From: Amanda Scholes on behalf of Planning.Responses
Sent: 19 July 2018 08:49
To: Planning Scanning
Subject: FW: Hares Dihatsu, Rustington
Attachments: RE: Renaissance - Rustington Drainage -Building Regulations

From: Anita Gardner
Sent: 18 July 2018 17:15
To: Planning.Responses
Subject: FW: Hares Dihatsu, Rustington

From: Chris Hendry [REDACTED]
Sent: 18 July 2018 16:28
To: Laura Gibbons
Cc: Ziyad Thomas; Anita Gardner
Subject: RE: Hares Dihatsu, Rustington

Scale: 1:125	Paper Size: A1	Date: JUNE 2017	Drawn By: JH	Checked By: CH
Project No. RRL012	Drawing No. 505	Revision: P4

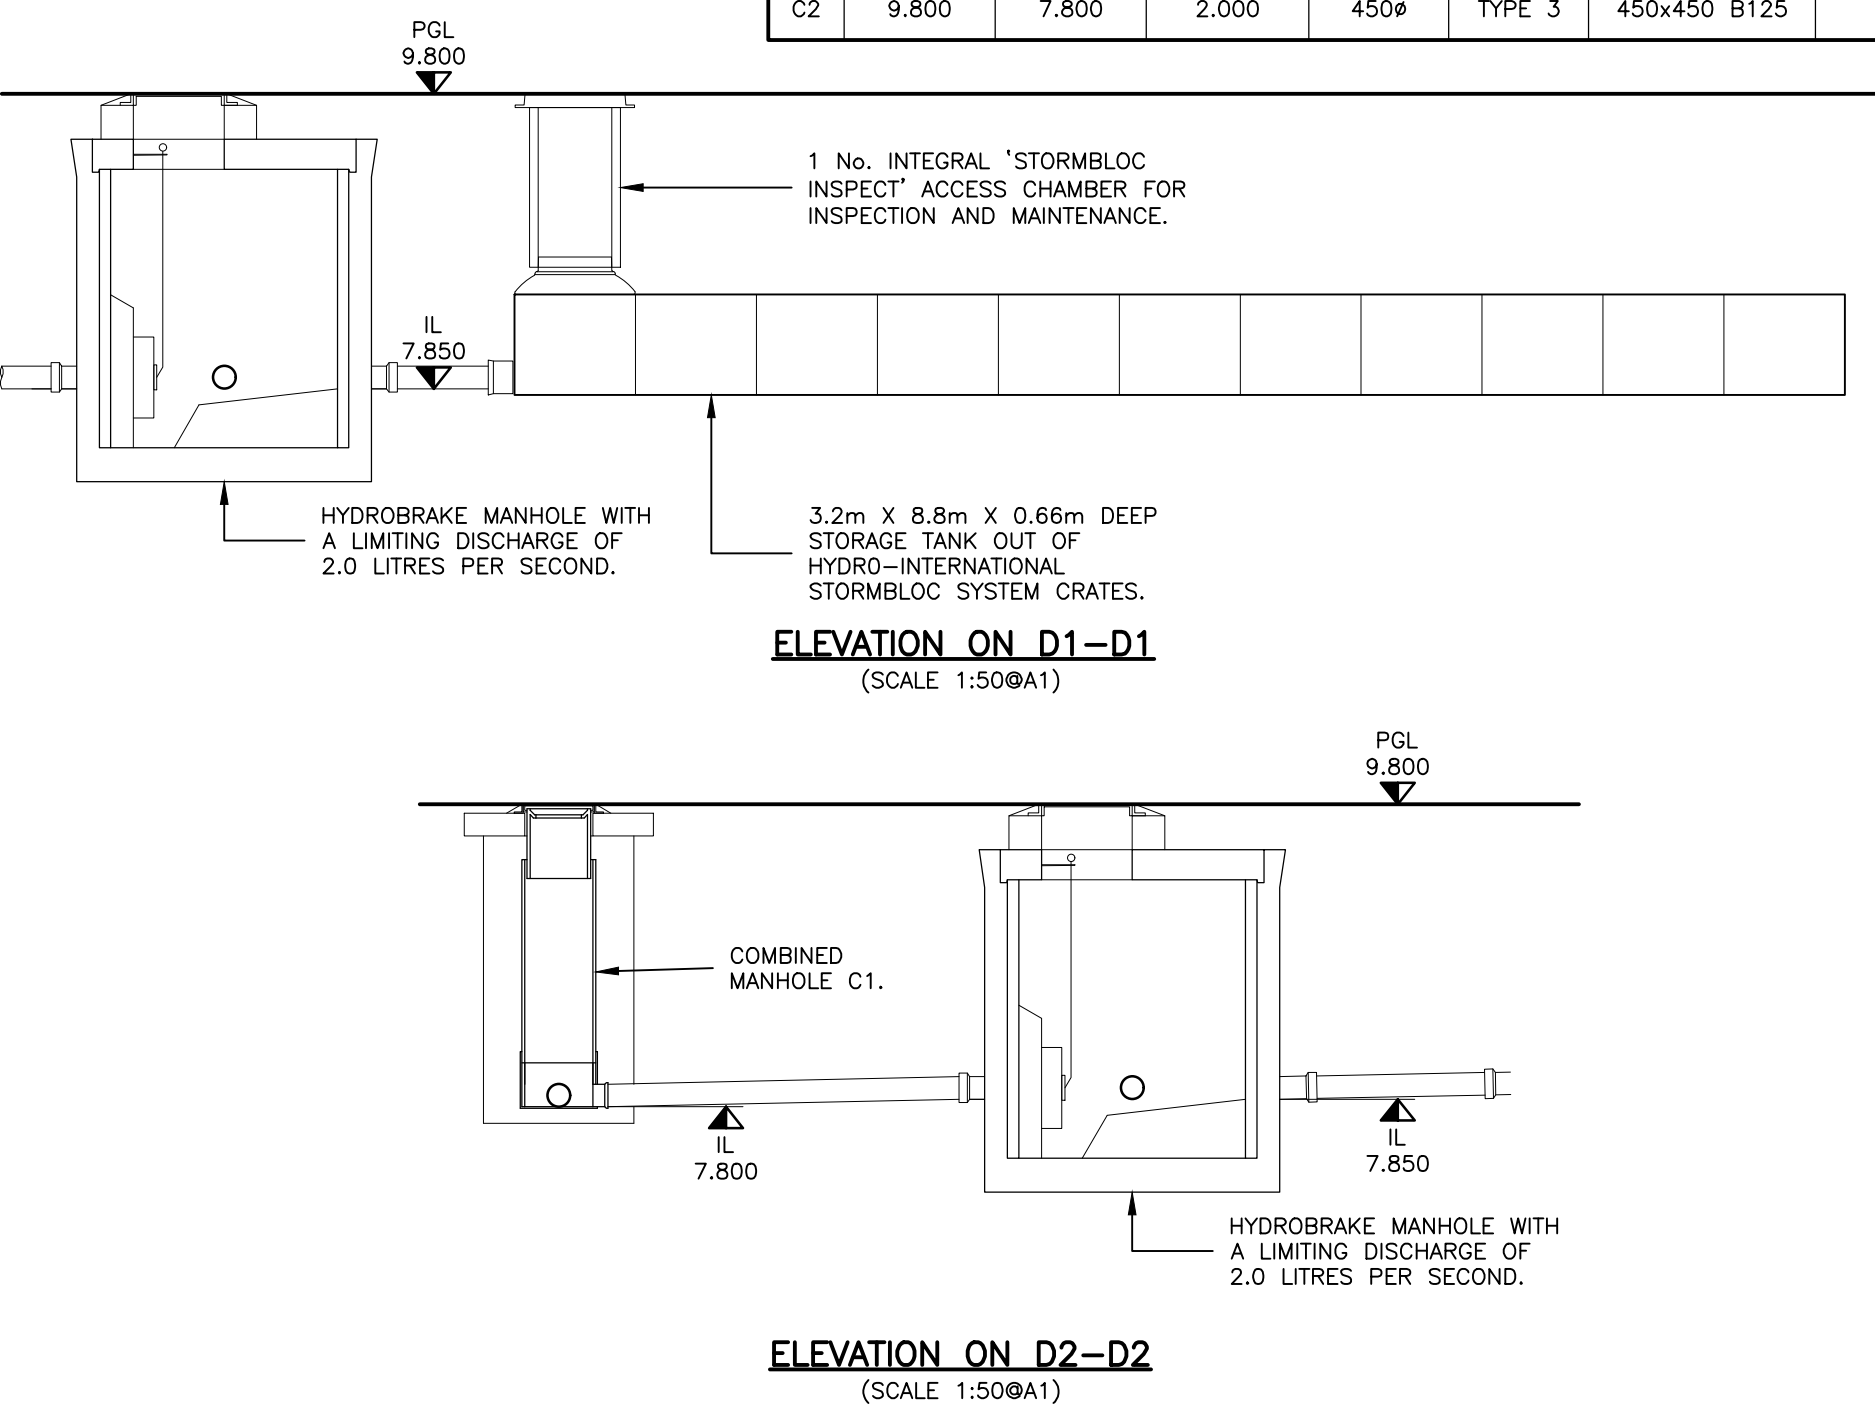
However, as stated within my consultation response further discussion and safety factors were required as March was after the peak of groundwater levels. Your statement below over simplifies the situation at this site.

You are also planning on discharging to a foul sewer. Which is what I want to remove, in line with Building Regulations and CIRIA I would like you to follow the hierarchy for surface water drainage disposal. You have not done this, and infiltration testing is required to show if it is possible to infiltrate more surface water. I asked if there were neighbouring sites to try to remove the need for this further testing. However, no sites are in true close proximity to the site.

The two sites that you have highlighted hint that infiltration for all surface water is achievable, but it seems likely it will need to be at a greater depth to get to more permeable layers. You will need to complete testing at the right depths in the winter to ascertain if this is indeed the case. I would recommend you contact me before you commence this to ensure it meets our requirements.

Winter groundwater monitoring is required when infiltration is to be used to ensure sufficient capacity is provided above the maximum winter groundwater level.

We undertook infiltration testing at the front of the site at 3.5m below ground in an attempt to reach the more permeable layers and it took 8 days to drain 1 metre of water as per my previous email.

Although we feel the clays above the chalk are not suitable for soakaways, we have done what we can to consider the hierarchy by the use of permeable paving. We have also attenuated the off-site storm flow to 2 litres per second, which Southern Water have agreed via the S106 application. I attach an email from Building Control in which they agree with this approach.

We can arrange for an outside geotech specialist to complete infiltration testing to BRE365 for your records. Please can you advise the depths at which you would like the testing? I suggest 1m (to prove the permeable paving), and 2m deep to investigate a buried soakaway. I do not believe anything deeper would be suitable as groundwater was found as high as 3.8m during the Phase II investigations and this was not during winter.

PERMEABLE BLOCK PAVING CONSTRUCTION DETAIL
(SCALE 1:10@A1)

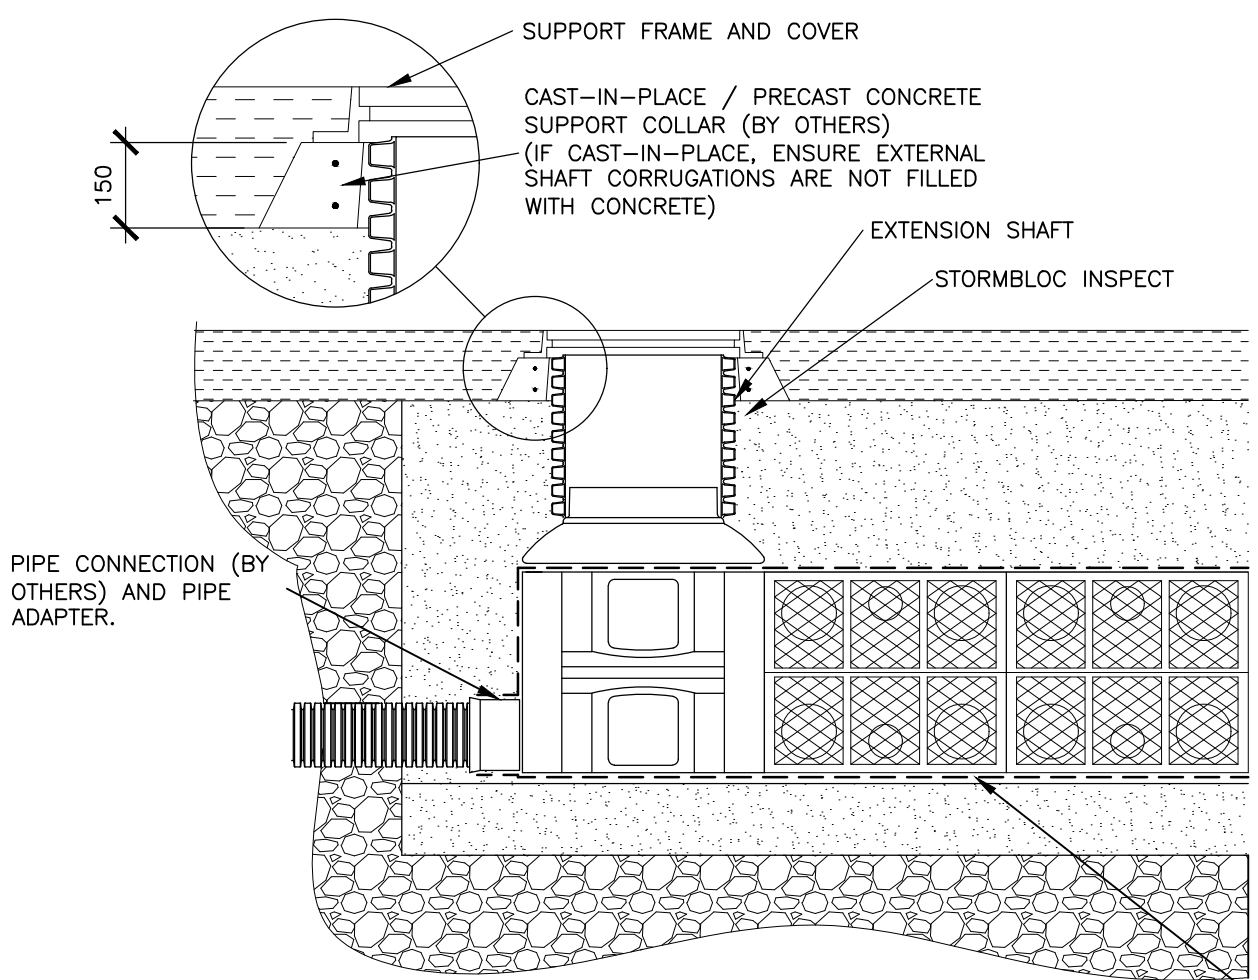
Winter groundwater monitoring was not provided in the SI report and the boreholes were done in spring. Groundwater was generally found to be at circa 4m in the chalk, though one result had it come up to about 2.5m. Are you concerned that this would rise so high that it renders the permeable paving inoperable?

Our site is further from the sea and 2m higher in level, so would it be acceptable at this stage to assume that the groundwater will not rise so much as to render the permeable paving on our site ineffective? We are not using deep buried soakaways like the site in Woodlands so I would hope this could be viewed favourably.

Drainage Layout

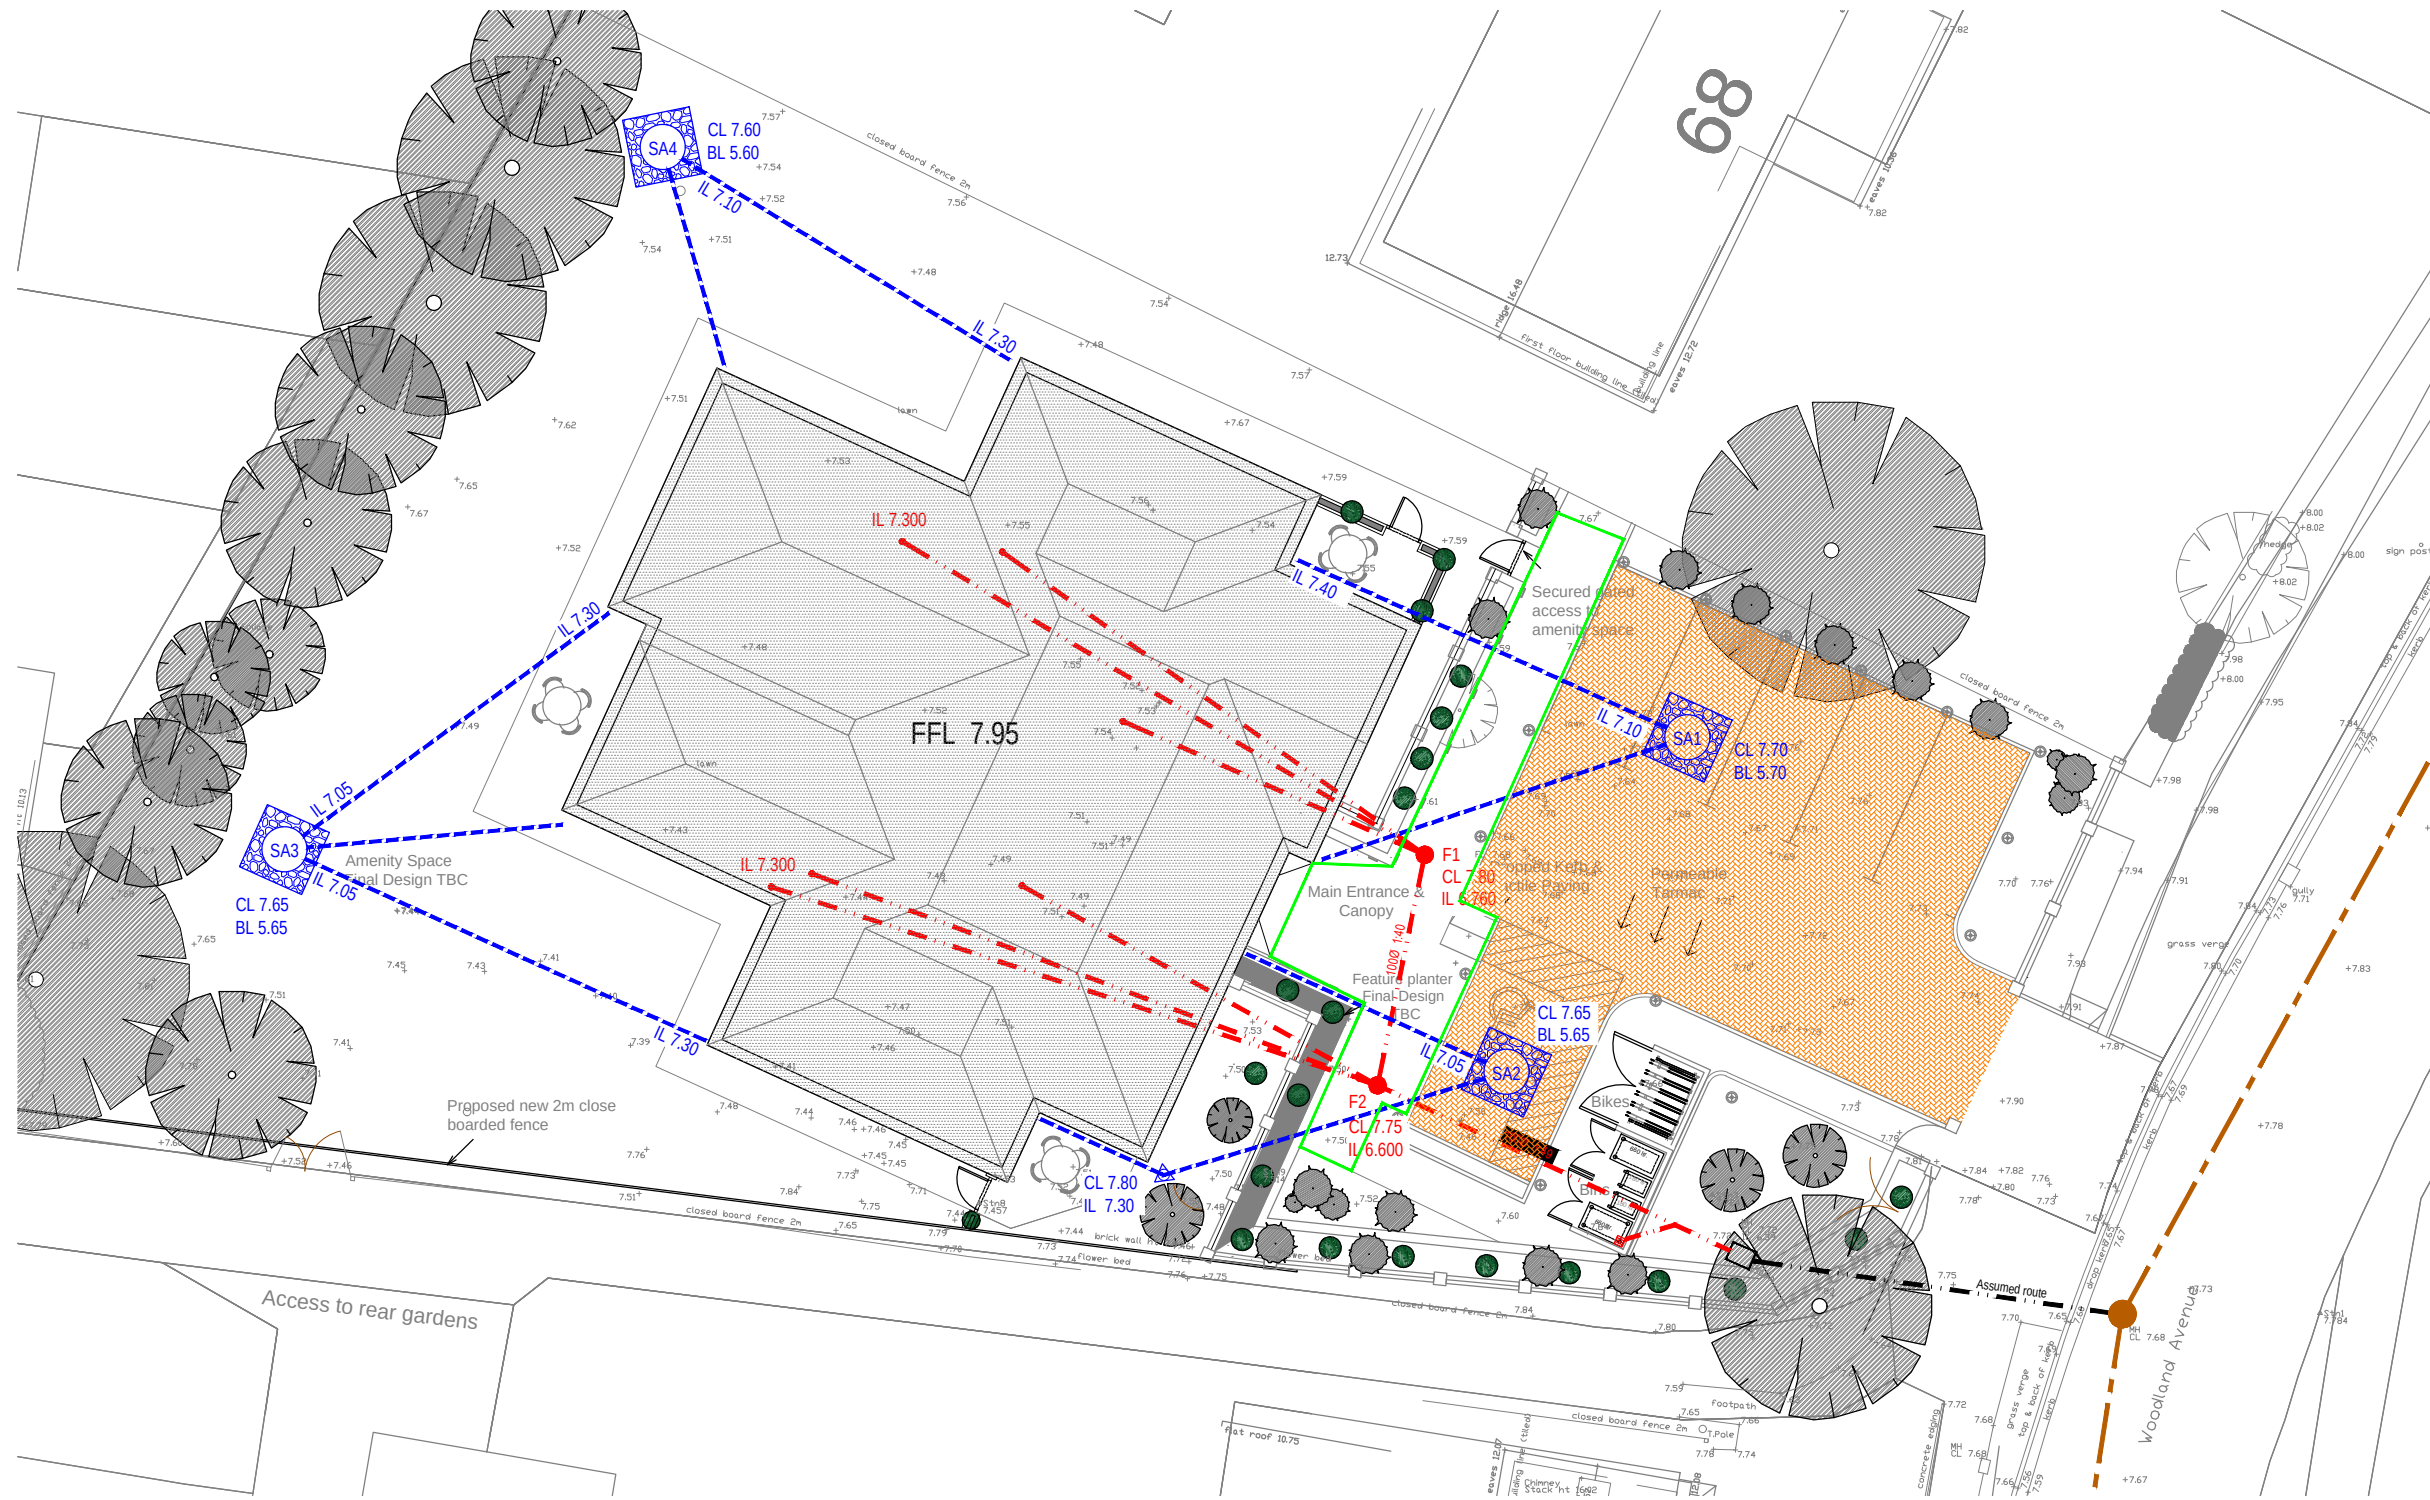
This application used 2m deep buried soakaways and only found evidence of groundwater once during their monitoring visits– in late February as per the drainage drawing attached.
